East Anglia ONE North and East Anglia TWO Offshore Windfarms

Applicants' Comments Charles Manning's Deadline 7 Submissions

Applicant: East Anglia TWO and East Anglia ONE North Limited
Document Reference: ExA.AS-25.D8.V1
SPR Reference: EA1N_EA2-DWF-ENV-REP-IBR-001022

Date: 25th March 2021
Revision: Version 1
Author: Royal HaskoningDHV

Diagram of Traffic Movements Assigned to the Highway Network

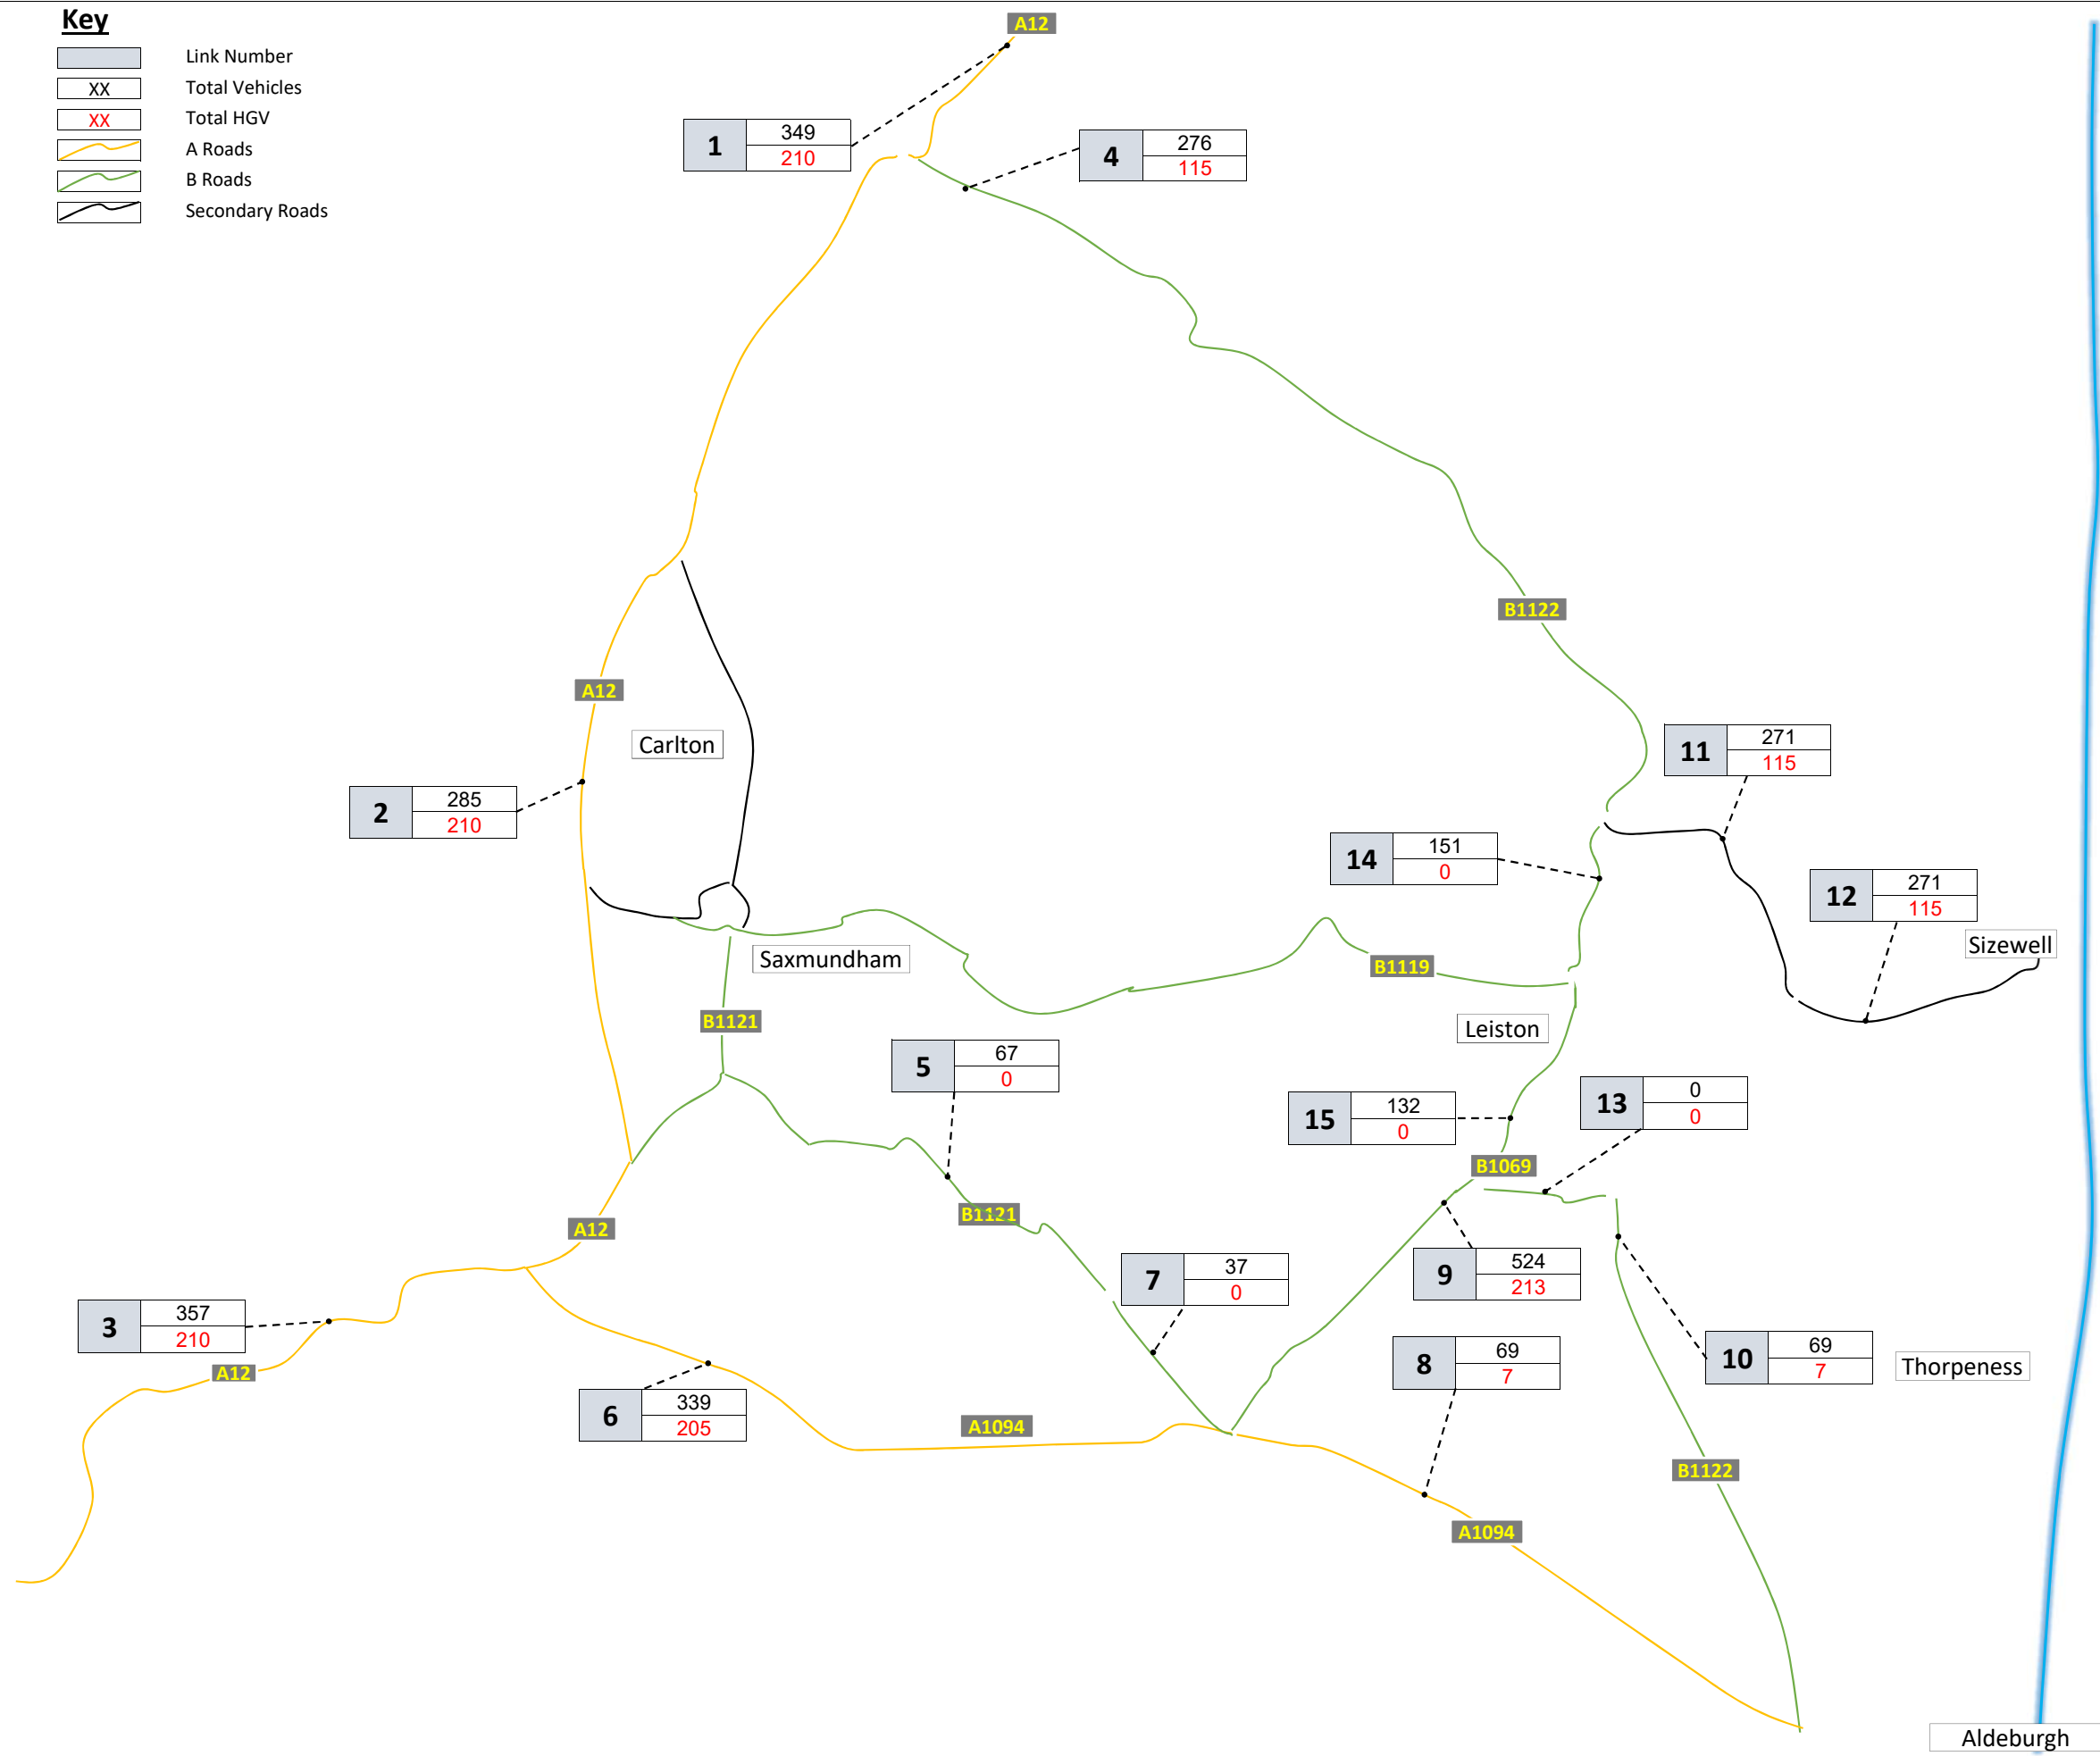
ID	Charles Manning's Comment	Applicants' Comments
1	<p>At previous local consultations meetings with Scottish Power personnel involved with planning the logistics for the Friston site, it was pointed out that the main road off the A12 to Aldeburgh (A1094) was not wide enough to accommodate two HGV vehicles to pass in opposite directions safely. The use of this road to carry traffic to and from the site would create high risk of accidents and consequent delays. Evidence of minor collisions by commercial vehicles on this road between Friday Street and Snape can be seen from debris left at the side of the road.</p>	<p>The A1094, is designated by Suffolk County Council as a 'Zone distributor route' within the Suffolk Lorry Route hierarchy". A Zone distributor route links the strategic routes across Suffolk to local delivery routes and therefore by definition has been assessed by the highway authority as a suitable distributor for assigning volumes of Heavy Goods Vehicle (HGV) traffic to local routes. In keeping with this designation there are no restrictions (height, width, or weight) on HGV movements on this link and it is deemed suitable for the Project's HGV demand.</p> <p>Section 26.6.1.10 of Chapter 26 Traffic and Transport (APP-074) contains an assessment of the potential road safety impacts resulting from an increase in the Projects traffic. With regards to the A1094 no significant impacts are identified.</p>

3	<p>A second potential issue arising from use of the A1094 is the risk that the B1069 would be used by HGV vehicles in the event that the</p>	<p>With regards to the potential for traffic to reassign from the A1094 onto the B1069 (through Snape), Appendix 26.2 (APP-528) details the Projects' peak</p>

ID	Charles Manning's Comment	Applicants' Comments
	A12 or A1069 become blocked by the increase in HGV traffic. It was suggested that this road (B1069) be subject to a maximum weight restriction between Tunstall and the A1094 at the Snape junction	construction traffic could result in an increase in total traffic of up to 5% on the A1094. An increase of up to 5% would be indiscernible from existing fluctuations in day to day traffic on the A1094 and therefore it is considered that the Projects' traffic would not lead to reassignment.
